Re: **Proposed: Utility Installation - MP 10-0133 - Gas Storage Facility**  
**Property: LOT: - DP: 999999**  
**Miscellaneous PORT STEPHENS**

Reference is made to the Departments correspondence received by Council on 16 June 2011, in relation to the proposed Newcastle Gas Storage Facility (10-0133).

Council has assessed the adequacy of the 'Environmental Assessment for Newcastle Gas Storage Facility', dated May 2011 and prepared by Coffey on behalf of AGL Energy Limited, and in response to your notification under Clause 75H of the *Environmental Planning and Assessment Act 1979*, provide the following comments:

Figure 6. APZ Separation Zones and Relevant Radiant Heat Flux.

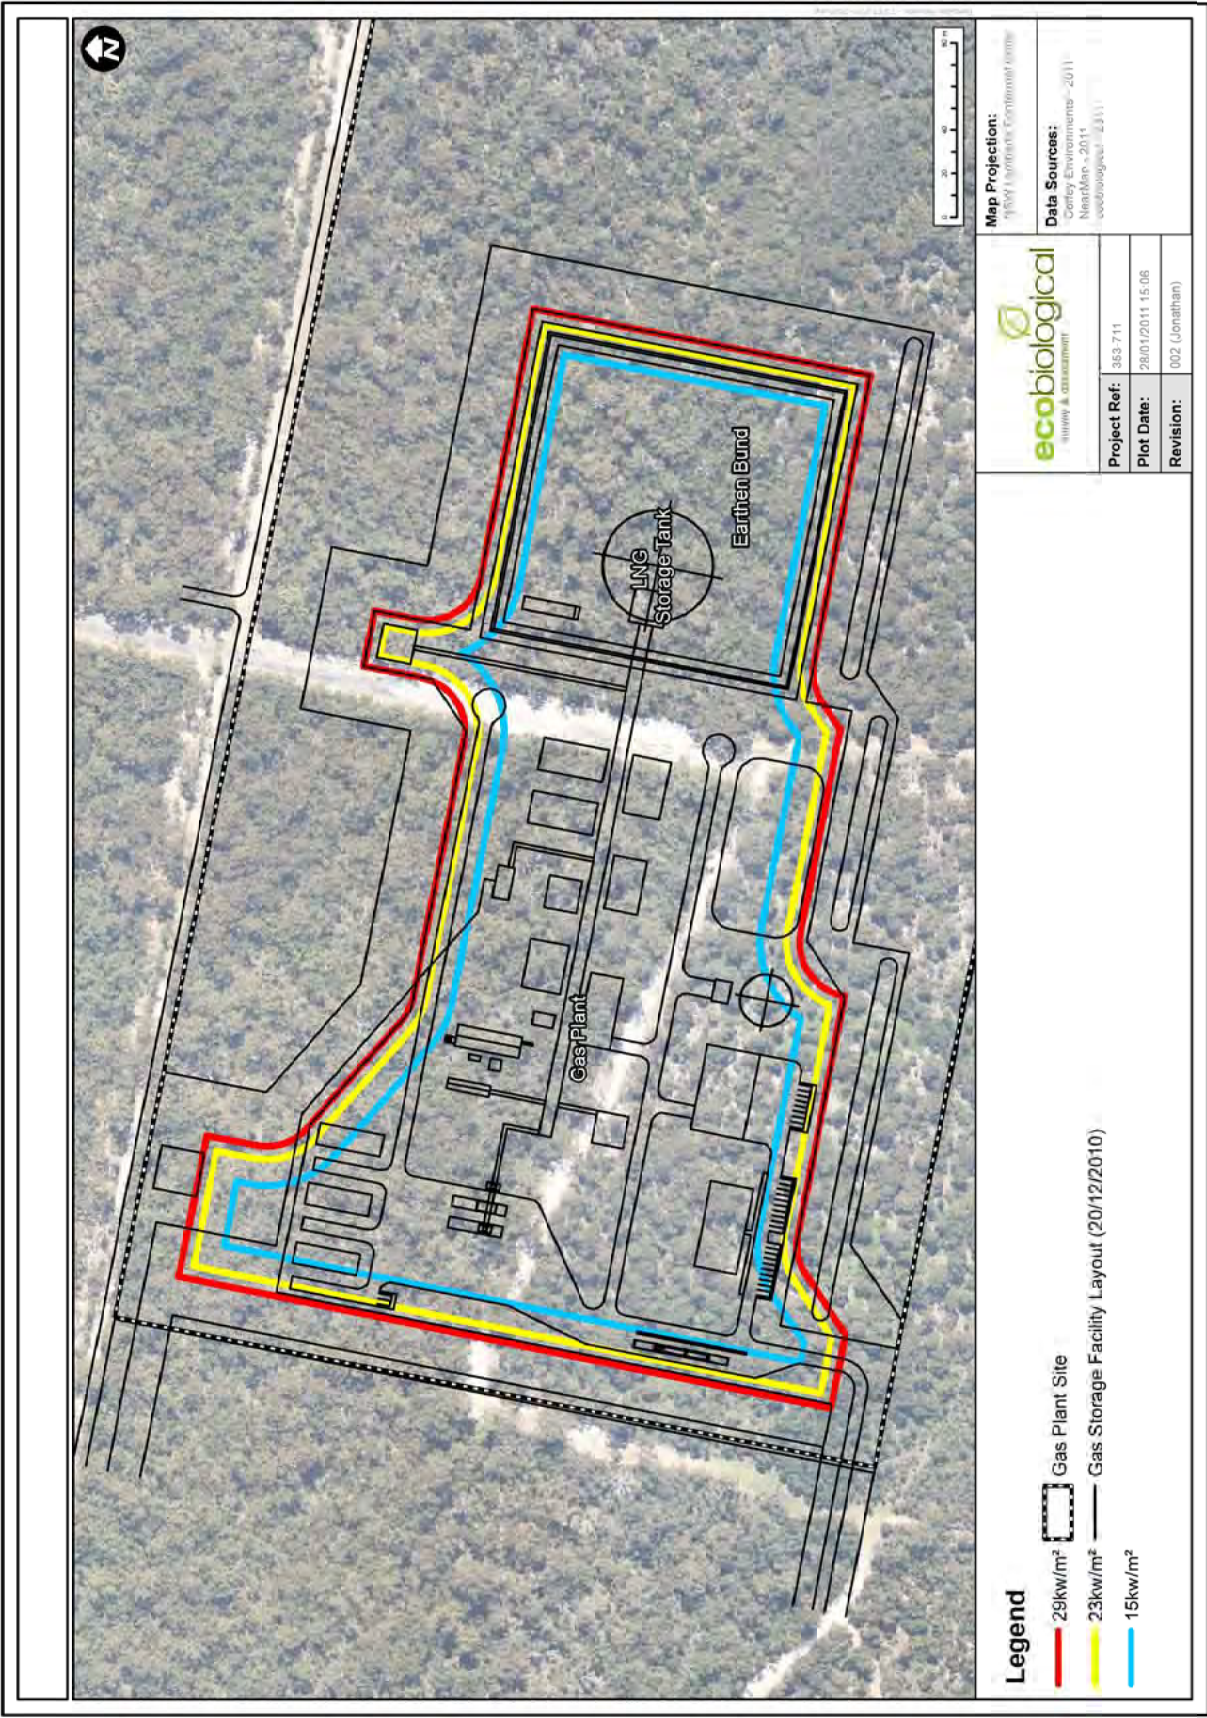
1. *Bushfire* - The Main Report provided with the Environmental Assessment states in relation to Bushfire that *"These APZs will be maintained in accordance with Inner Protection Areas standards to ensure vegetation is kept at less than 0.05 m in height."* Council notes that this is not in line with Planning for Bushfire Protection whereby trees can be retained as long as there is canopy separation, and clumps of understorey vegetation can be retained as long as they do not provide a path for fire to the asset. The Department should ensure that APZs on site are amended so as to be aligned with Planning for Bushfire Protection.
2. *Water Supply* – It is recommended that provision and/or construction of water supply infrastructure be designed and/or carried out so as to ensure that impact to

A 25m APZ and a 31m APZ around the processing plant and storage tank, is proposed for bushfire mitigation. Without a clearer picture/ plan of how this relates to the Swamp Mahogany Forest in the far eastern end of the development area, it is thought the APZ would likely impact or degrade the Swamp Mahogany forest.
